A Trough
45, Leeds Old Road
Heckmondwike
WF16 9AAKirklees Direct
Tel: 01484 414746
Email: molly.storer@kirklees.gov.ukDate: 03-Jul-2025
Our Ref: 2025/91474

TOWN AND COUNTRY PLANNING ACT 1990
TOWN AND COUNTRY PLANNING (GENERAL PERMITTED DEVELOPMENT) (ENGLAND)
ORDER 2015 – SCHEDULE 2, PART 1, CLASS A.1 (g)
AT: 45, Leeds Old Road, Heckmondwike, WF16 9AA
Prior notification for single storey rear extension

The Authority has considered your application and it has been determined that the proposal is not acceptable and prior approval is hereby **Refused** for the following reason(s);

DRAWING TITLE  
Proposed Layout

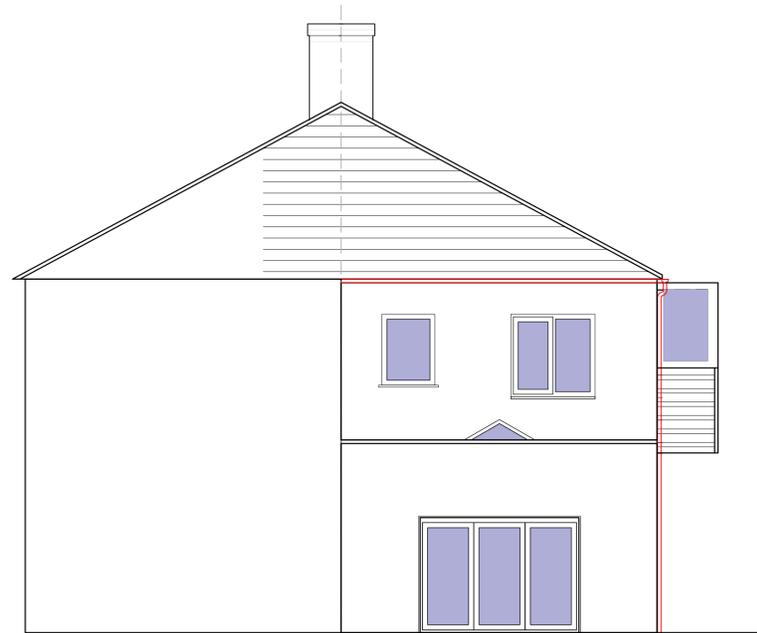
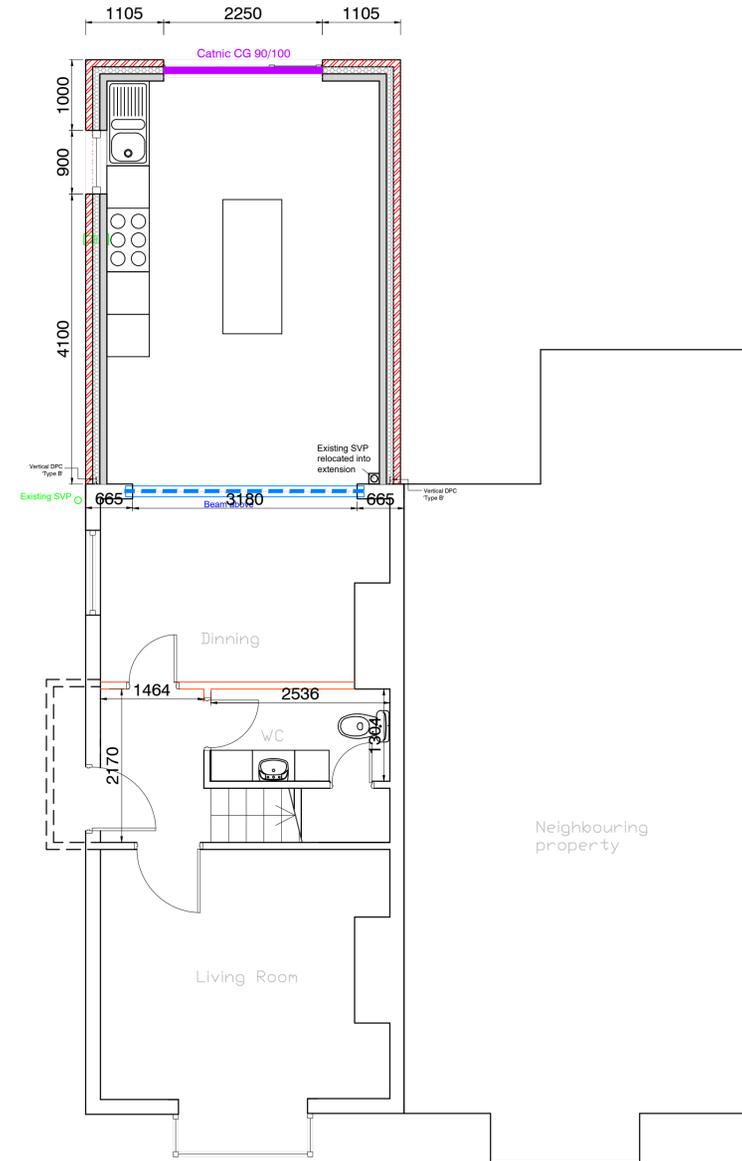
The proposal is for erection of single storey rear extension. The extension projects 6m beyond the rear wall of the original dwellinghouse. The maximum height of the extension is 2.5m, the height of the eaves of the extension is 2.5m

The proposed enlargement does not benefit from a general planning permission under Article 3(1) and Class A, Part 1 of Schedule 2 of the Town and Country Planning (General Permitted Development) (England) Order 2015 as the rear projection extends beyond a wall forming a side wall of the original dwellinghouse and has a width greater than half the width of the original dwellinghouse contrary to sub-paragraph A.1(j) of Class A.
